MEMORANDUM

DATE: December 21, 2022

SUBJECT: **On-Call Contract #17-067H-1; PO # 8115428**
Traffic Impact Study Reviews
Task Order #7: 4-Square at Sterling Ranch East Traffic Technical Memorandum - Second Review (PUDSP227)

Figure 2  
**Site Plan**

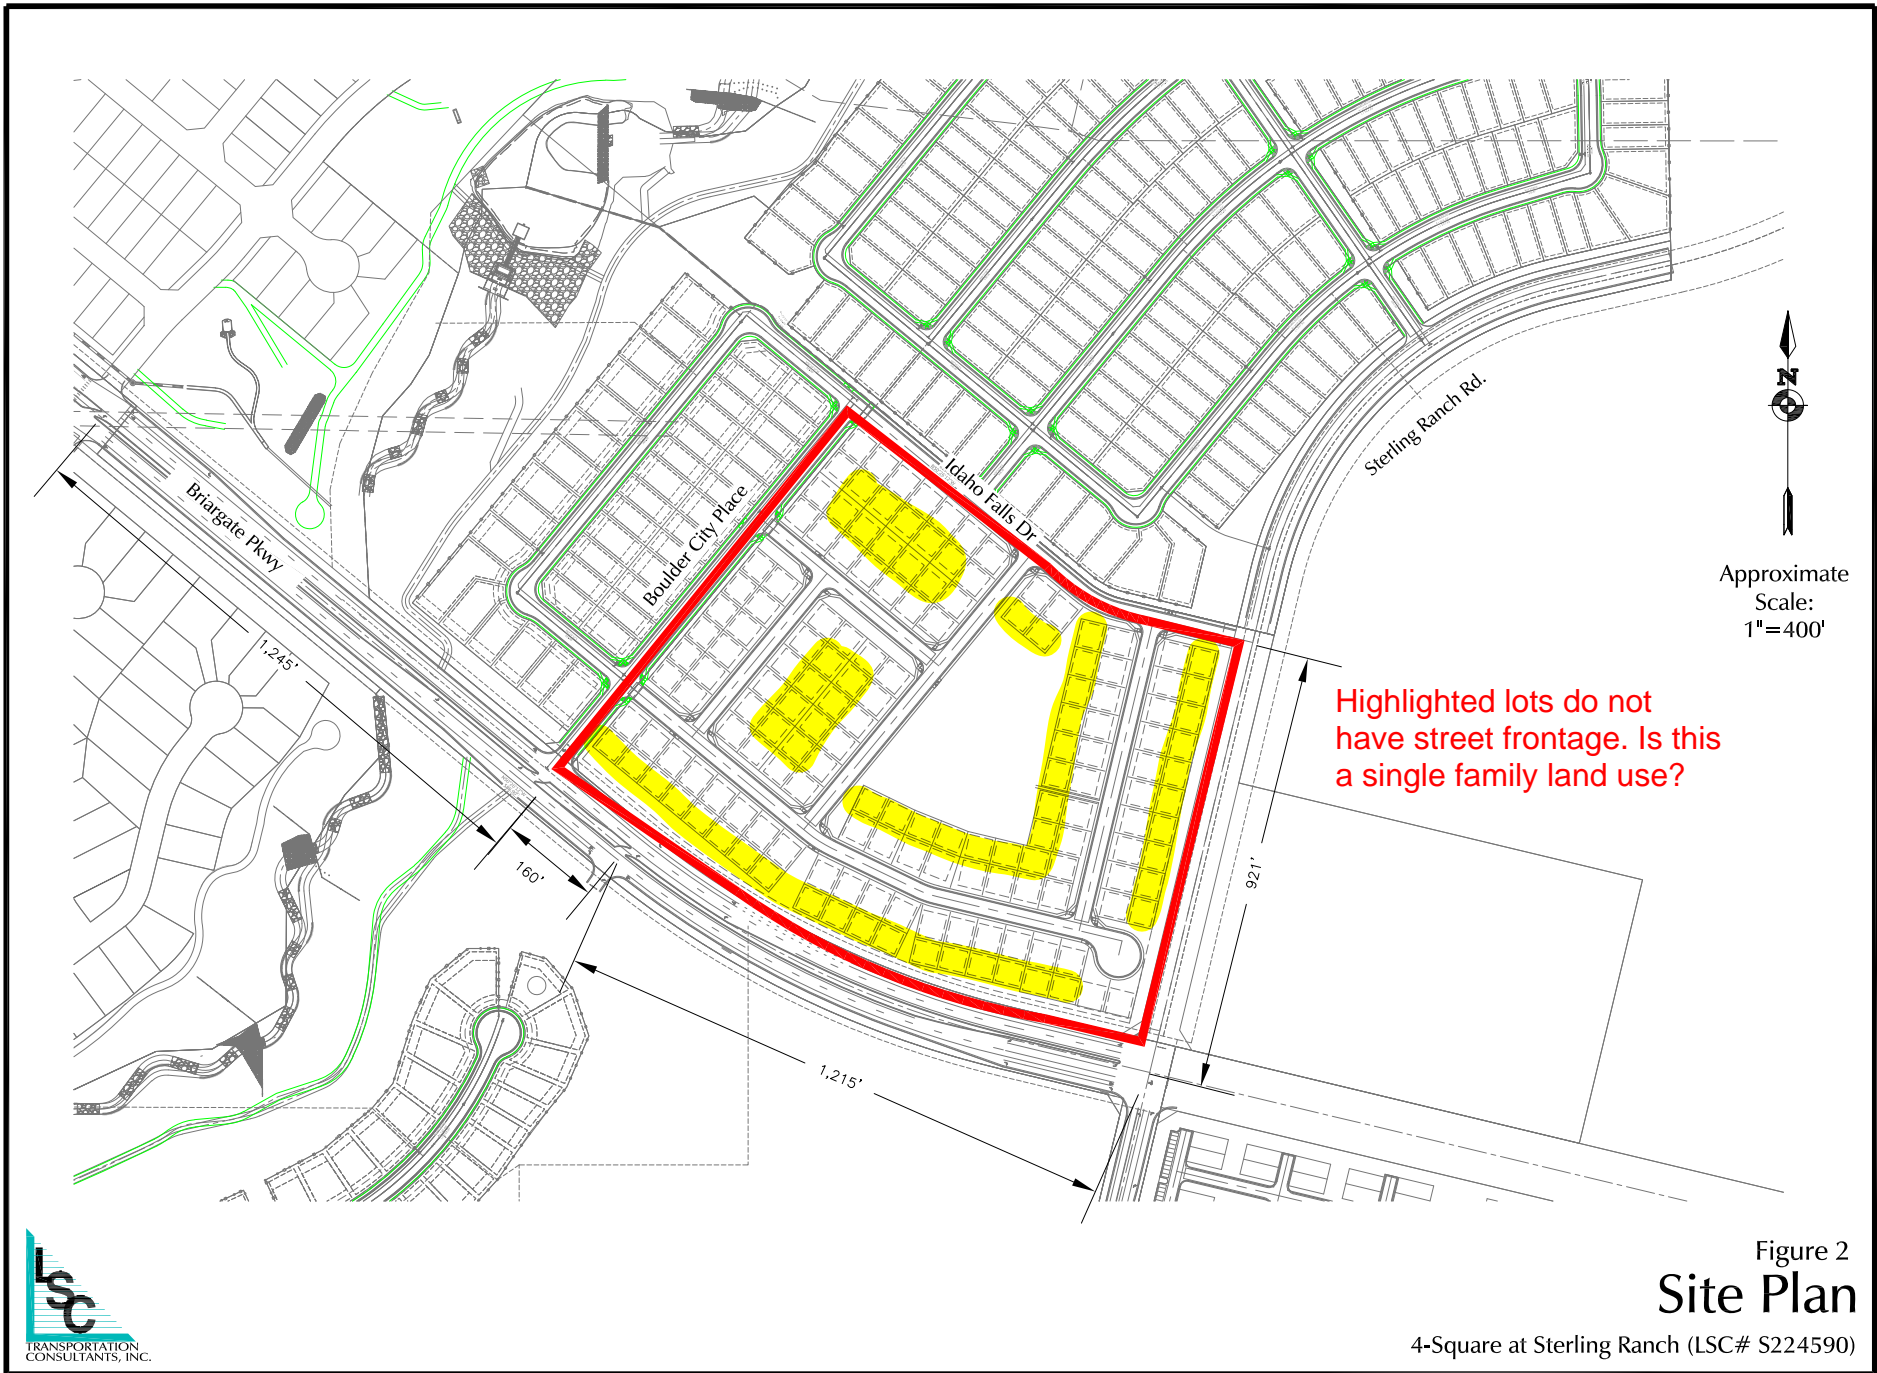
4. The memorandum identifies a single-family residential land use in the 4-Square study area. However, the site plan (Figure 2) shows that approximately half of the study area lots will not have street frontage. This lot layout is more typical of higher-density multi-family residential. The applicant should either select a higher density land use for analysis or justify the use of the single-family land use for what appears to be a higher density development. If the land use type is changed, the update will need to be coordinated with other referenced TISs.
